KIRKLEES METROPOLITAN COUNCIL INVESTMENT & REGENERATION SERVICE

DELEGATED DECISION TO DETERMINE PLANNING APPLICATIONS TO CARRY OUT DEVELOPMENT WITHOUT COMPLIANCE WITH PLANNING CONDITIONS PREVIOUSLY ATTACHED

Reference No:	2026/70/90373/E
Site Address:	land northwest of, Urban Terrace, Denby Lane, Grange Moor, Huddersfield, WF4 4EB
Description:	Variation of conditions 2. (plans) 10. (attenuation tank) & 27. (landscaping) on previous permission no. 2023/93704 for erection of 12 dwellings and associated works
Recommending Officer:	William Simcock

Proposed Bin Store Phasing Plan
1 : 250

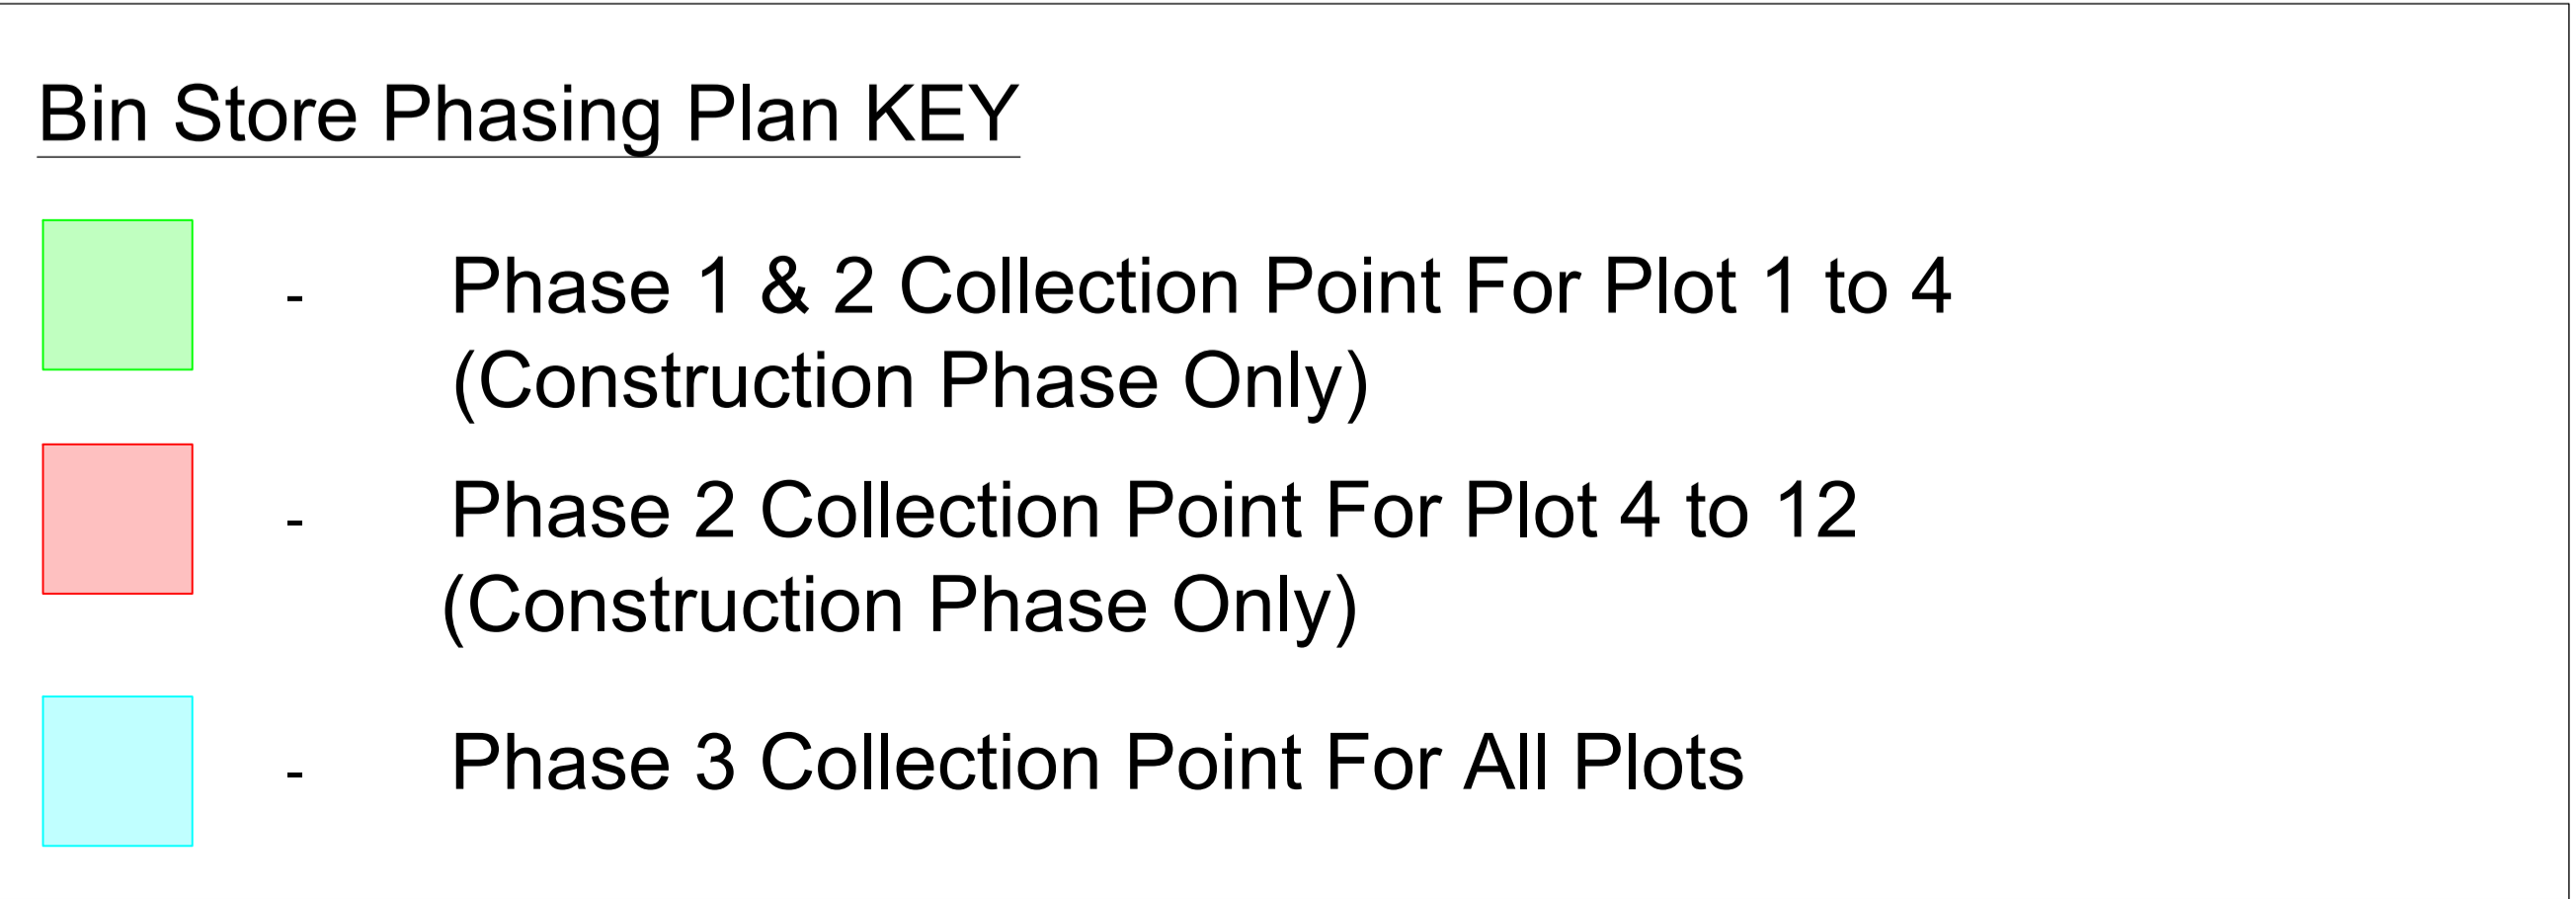
20/05/2026: Minor amendments to site plan to ensure that bin collection points were accessible to collection crews.

Each dwelling would have its own bin store and its own bin collection point, all of which would be adjacent to the footway and therefore easily accessible by bin collection crews. The original approved layout showed, in addition to these, a shared bin collection point to the east of the access, intended as a fall-back measure in the event that bin collection crews were unable or unwilling to collect from the estate road. This feature is not explicitly shown on the current proposed site plan although there is a hard surfaced area that could fulfil this purpose. It appears that the shared bin collection point was included as a precautionary measure on the original plans, but KC Waste have confirmed that even though the street is not intended to be adopted, the proposed layout is suitable for access for a refuse collection vehicle and that provided the turning head is not obstructed by parked cars, there is no reason why Kirklees Council bin collection crews will not be able to collect from within the estate. The proposal contains, as previously noted, private and visitor parking meeting adopted Kirklees standards and there is therefore no reason

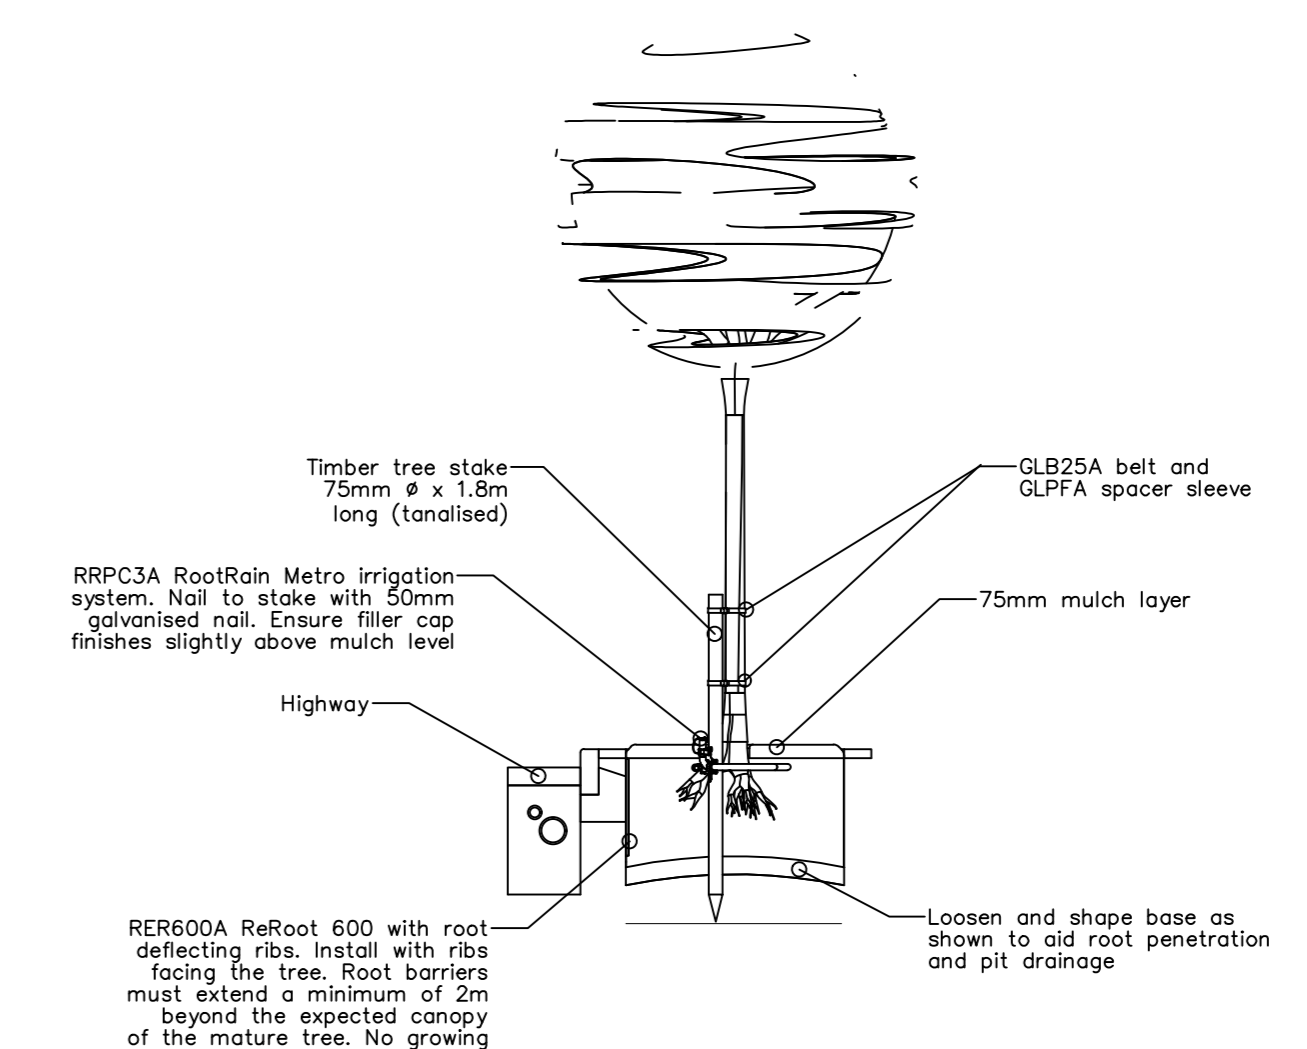
KC Landscape, in making informal comments on the proposals, expressed the following concerns about the scheme:

- Trees within curtilages of Plots 5-8 planted over or close to drainage runs;
- Lack of clarity as to location of root barriers.
- Lack of detail concerning species, planting densities, etc.

The developer's agent was advised during the application process that the planting of trees above or close to drainage pipes within Plots 5-8 would give rise to the risk of future maintenance problems owing to root incursion, and the proposed trees have now been removed from these plots and substituted with trees elsewhere in the site. The NPPF (paragraph 136) recommends that all new streets are tree-lined. It was accepted in the assessment of the original application that the planting of true street trees would not be practicable since there was to be no footway within the estate road, but that the majority of trees would be within dedicated open space and other managed areas, and others would be within gardens that face the new estate road. It is considered that the loss of the proposed trees from the front gardens of Plots 5-8 would not result in a reduction in the quality of the landscaping scheme overall since there would not be a net reduction in the number of trees and the majority would still be within public open space areas where they would still offer a clear benefit to public amenity.

The latest plans however show the installation of a root barrier along the Denby Lane frontage to prevent root incursion into the new footway (which will be adopted) from the *Fagus sylvatica* hedge, at locations within the site where trees and hedgerows are particularly close to the estate road or parking spaces, and surrounding the proposed attenuation tank.

27. All hard and soft landscape works shall be carried out in accordance with the landscaping scheme 3875/2 Rev Q and external works plan 0740 Rev P15 within the first planting, sowing or landscape management season following the substantial completion of development and prior to the occupation of any part of the development. Thereafter, the landscaping scheme shall be maintained and managed in accordance with the approved Landscape Management Specification authored by Rosetta Landscape Design, Revision A, and submitted 19/11/2024 in support of application 2023/93704.
